MECKLENBURG COUNTY
Land Use & Environmental Services Agency

MEMORANDUM

To: Charlotte-Mecklenburg Planning Commission
From: LUESA, Mecklenburg County
Date: 1.26.22
Subject: Rezoning Petition Comments

2021-079: Wendover Plaza

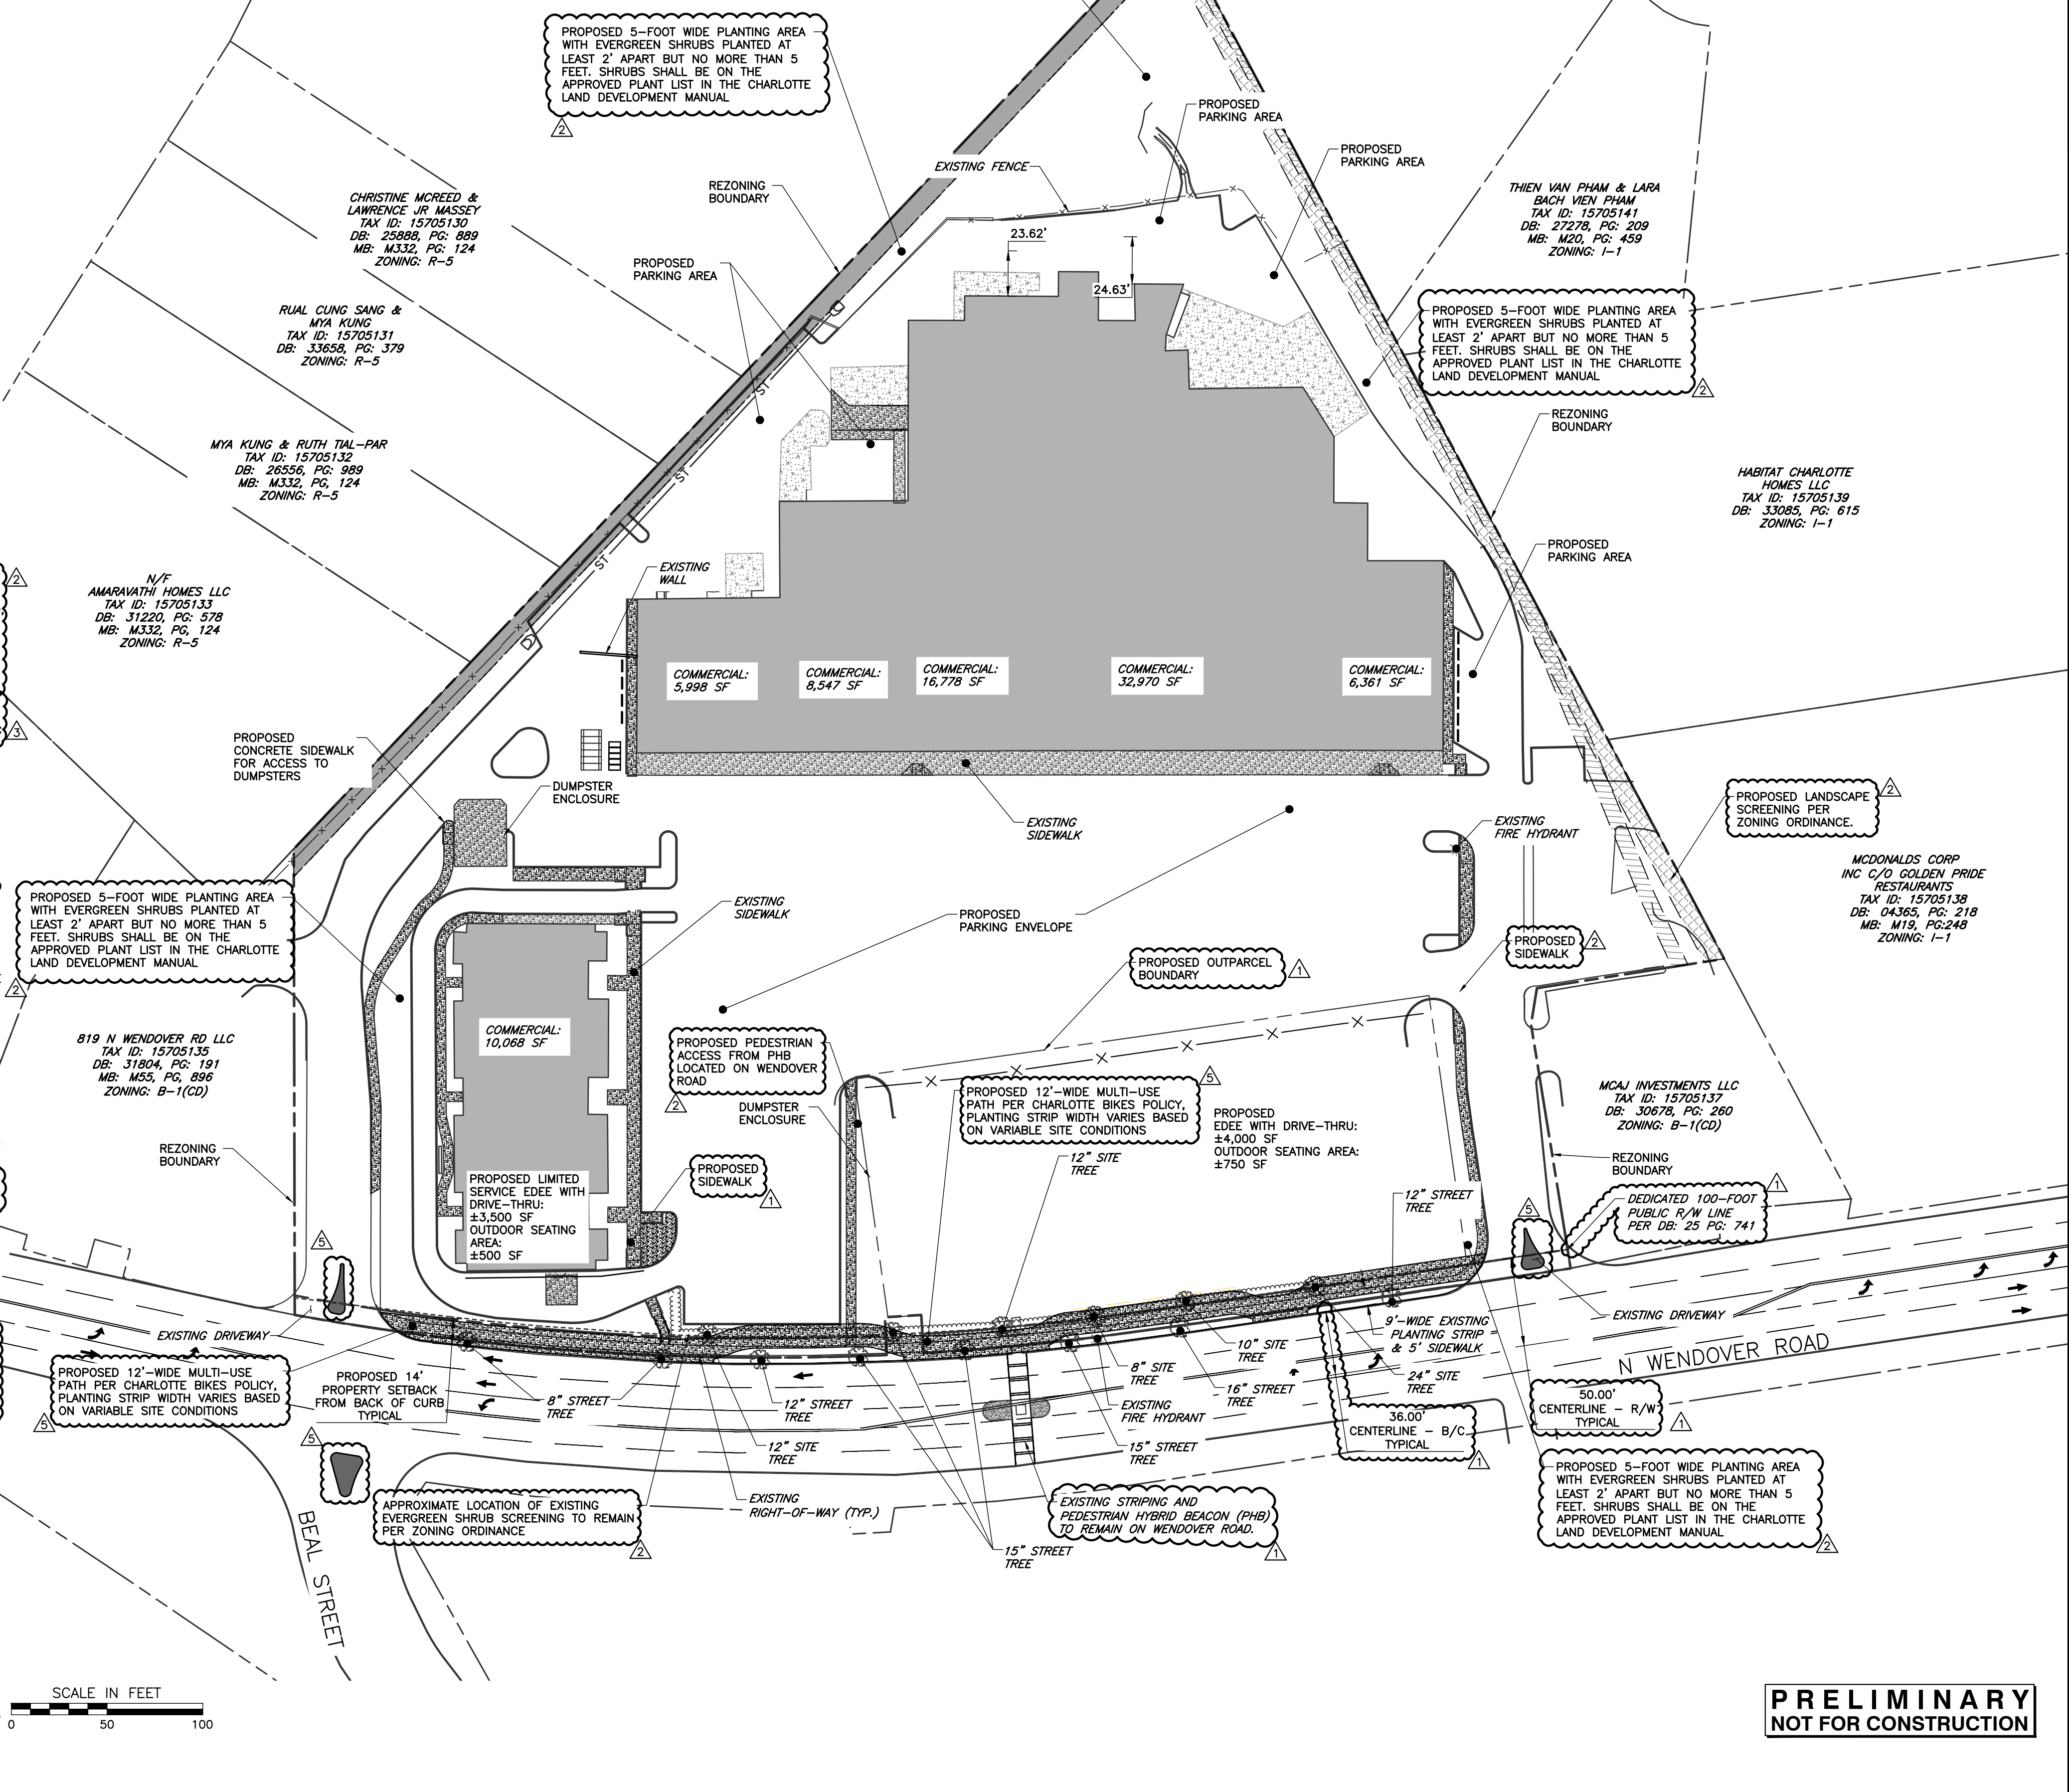
Solid Waste Comments: Site plan should show equal space for Solid Waste and Recycling Storage
